THE THURROCK FLEXIBLE GENERATION PLANT DEVELOPMENT CONSENT ORDER

Written Representations submitted on behalf of the Port of London Authority

PINS Reference Number	EN010092
Interested Party Reference Number	20025539
Document Ref.	PLA 4
Author	Winckworth Sherwood LLP
Date	23 March 2021

Rev	Date	Remark
APFP Regulations Reference: 5(2)(j) Application Document Number: A2.3		
Thurrock Flexible Generation Plant Work Plans Sheet 5 of 6

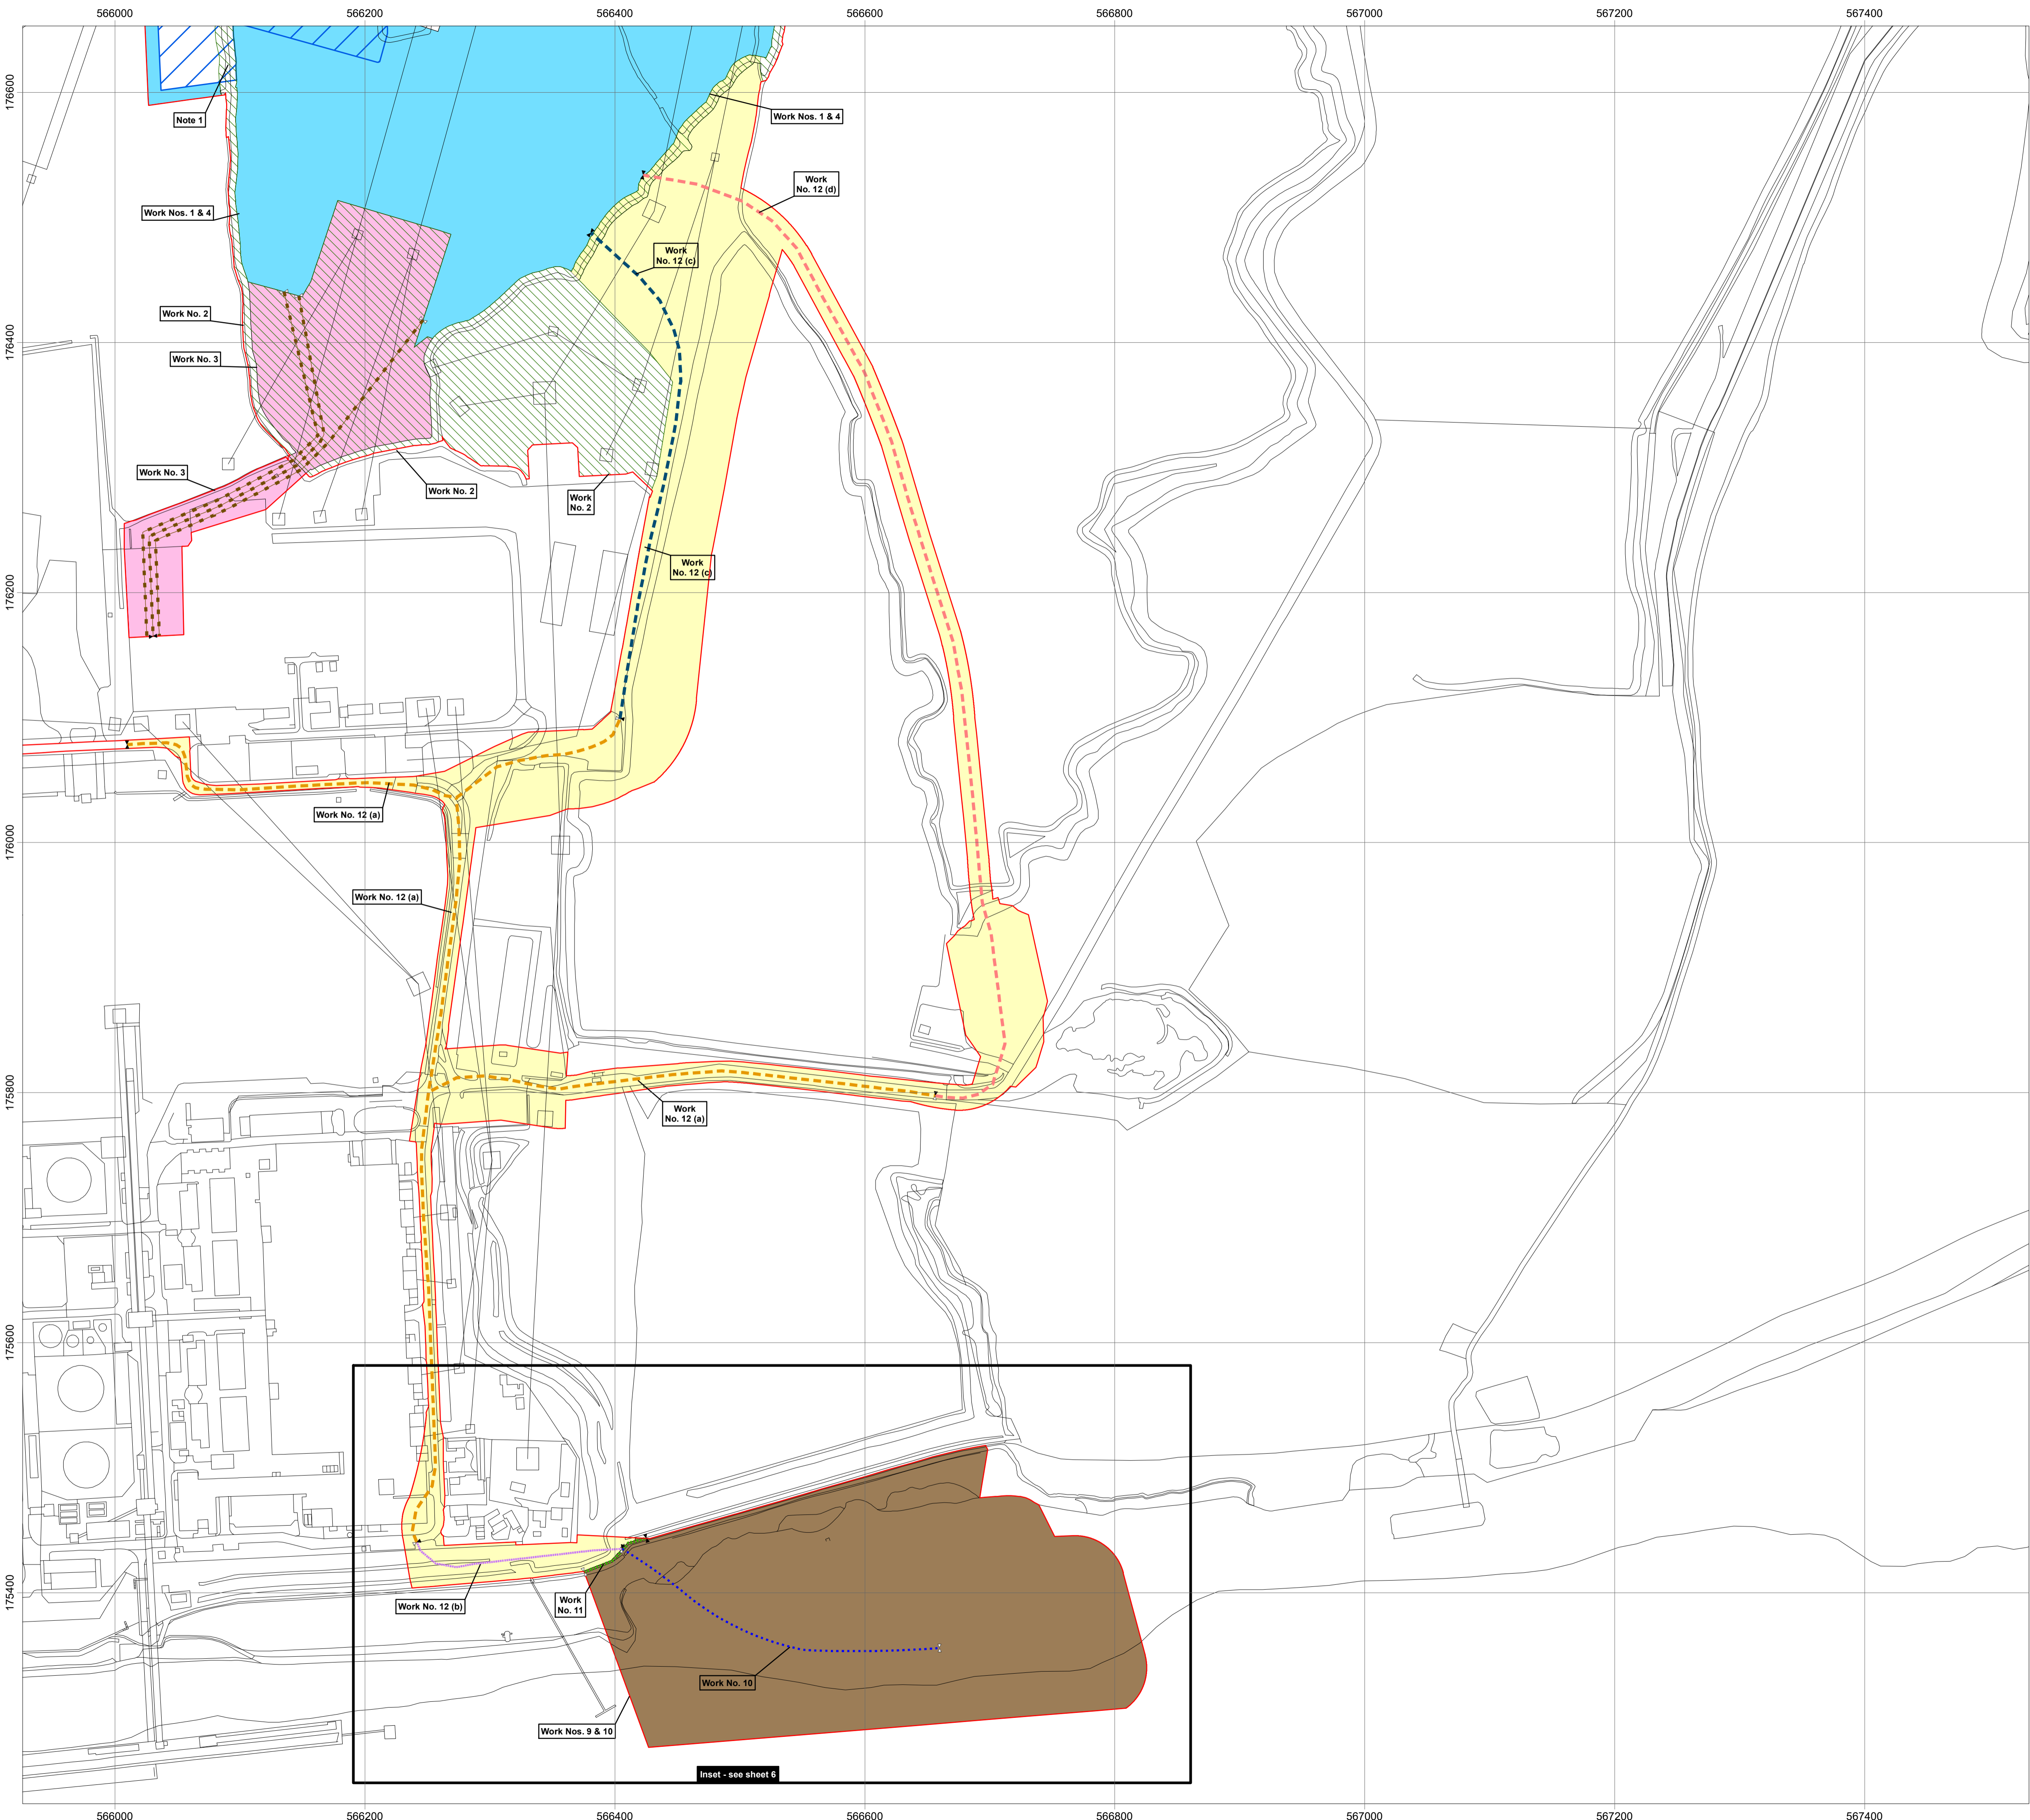
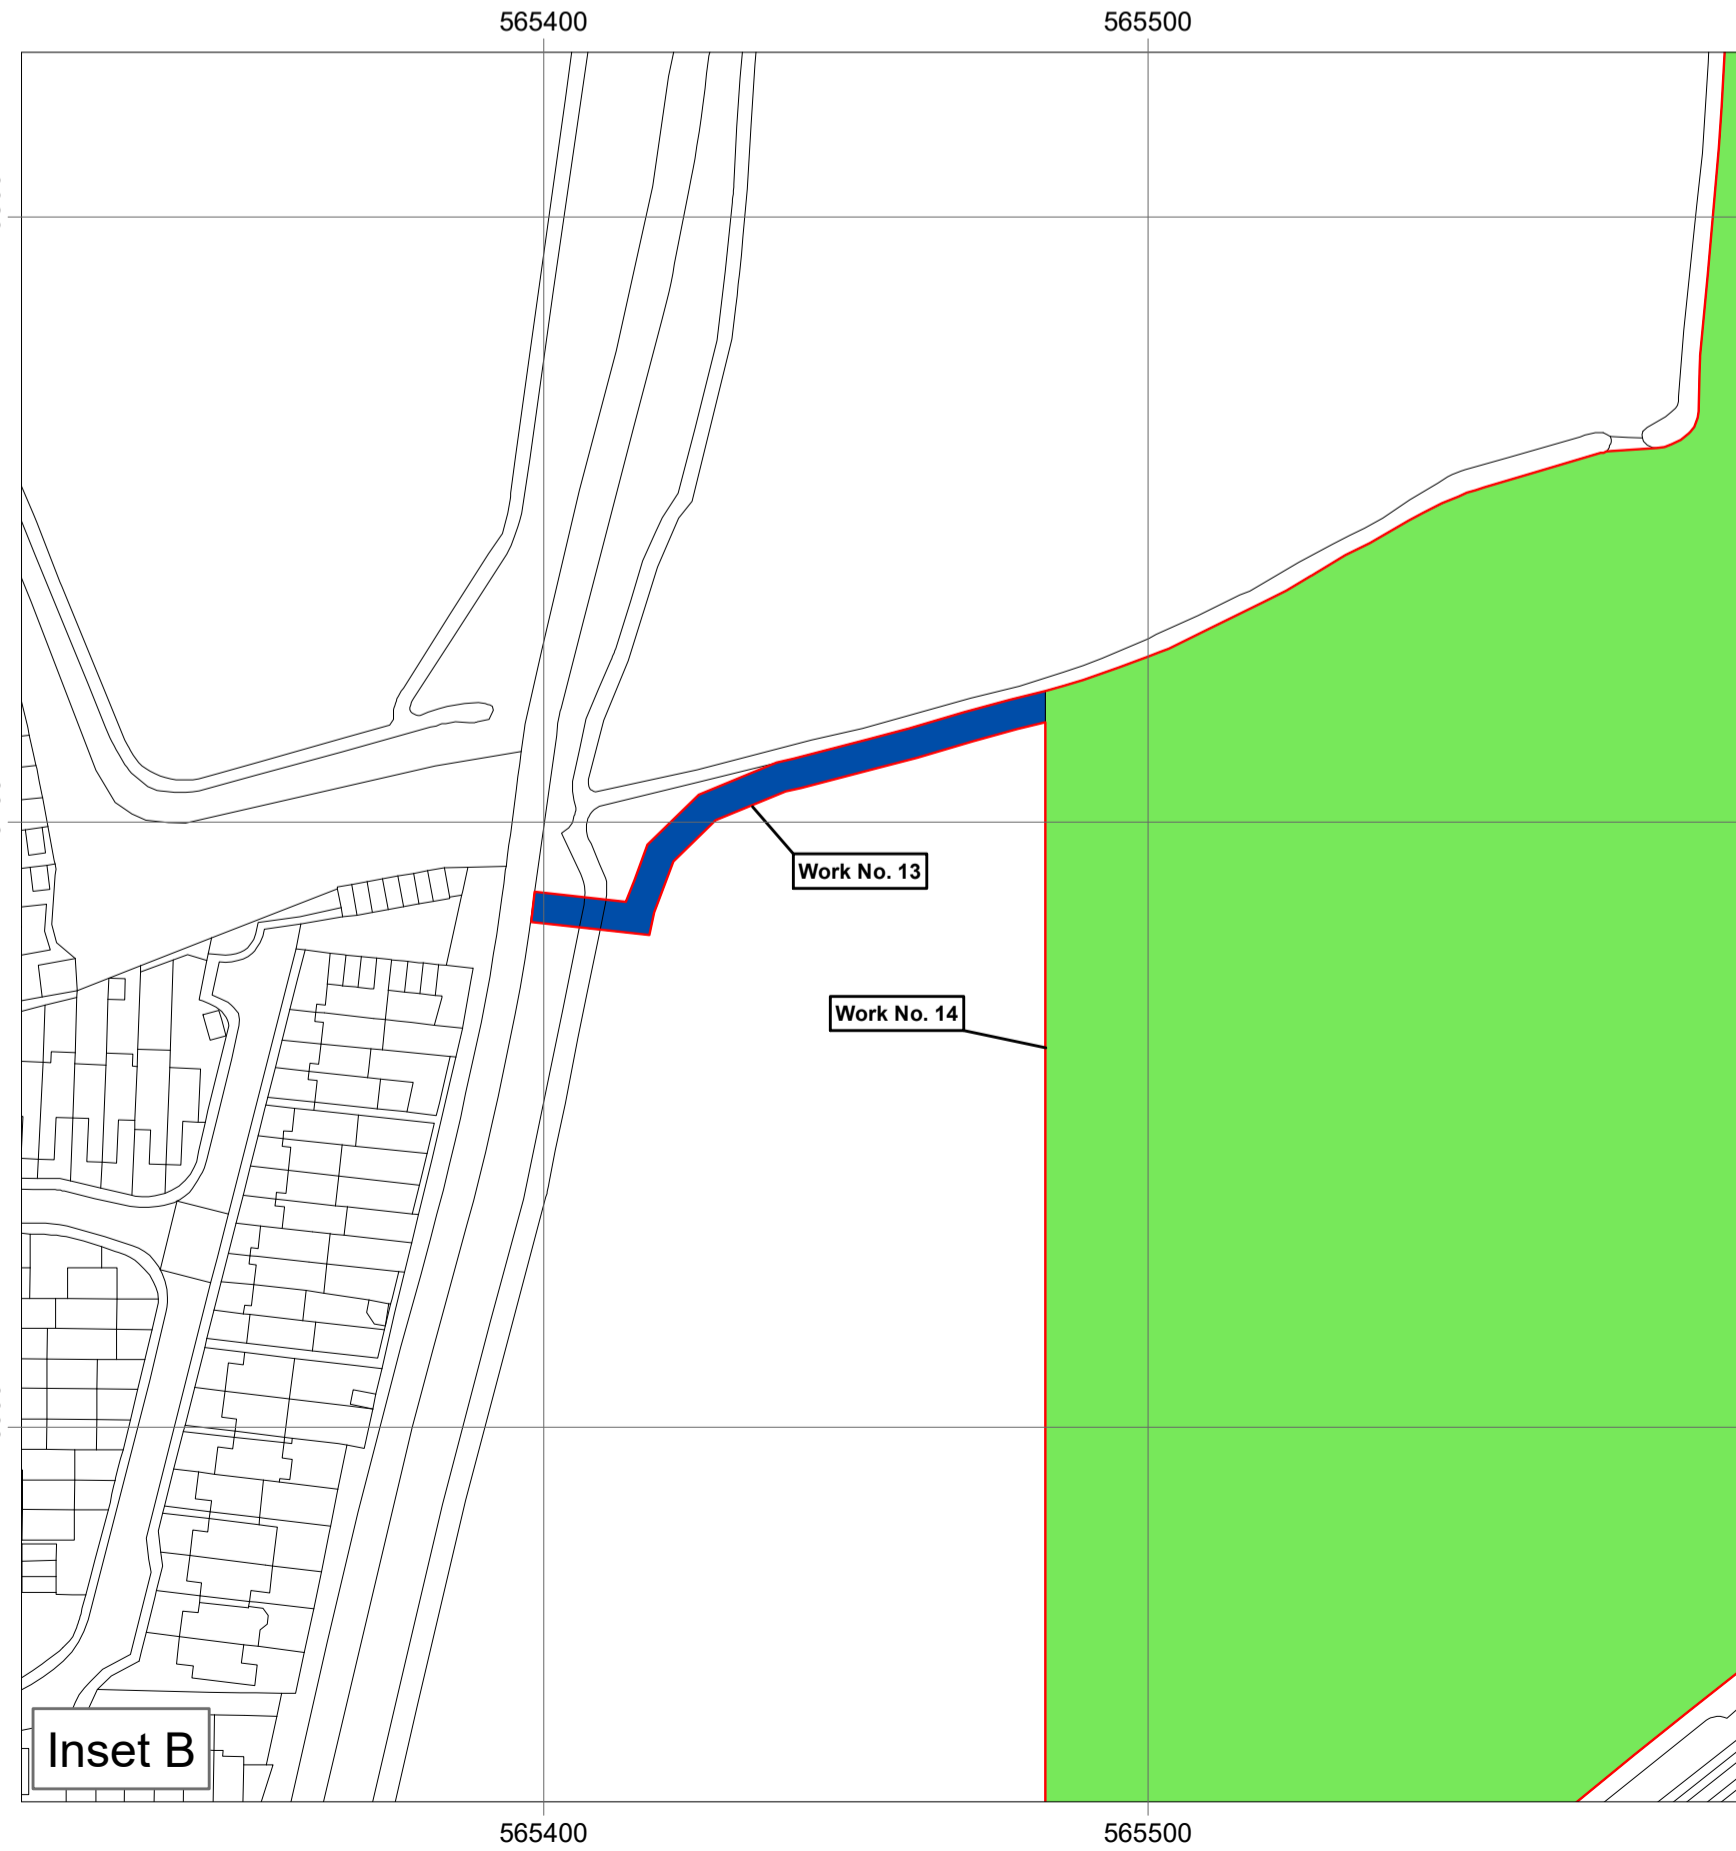
- 4.4 The PLA was concerned to see that there was no reduction in the Limits of Deviation of Work no.10 as part of the change request submitted to withdraw the saltmarsh enhancement proposal. It is understood that TPL does now intend to submit a revised Works Plan with a reduced limit and the PLA was sent draft Rev 3 of sheet 6 on 18 February 2021. If that Plan is submitted to the Examination, and subject to adequate drafting being included in the DCO to secure the causeway design, the PLA is content with the Limit of Deviation for Work no.10.
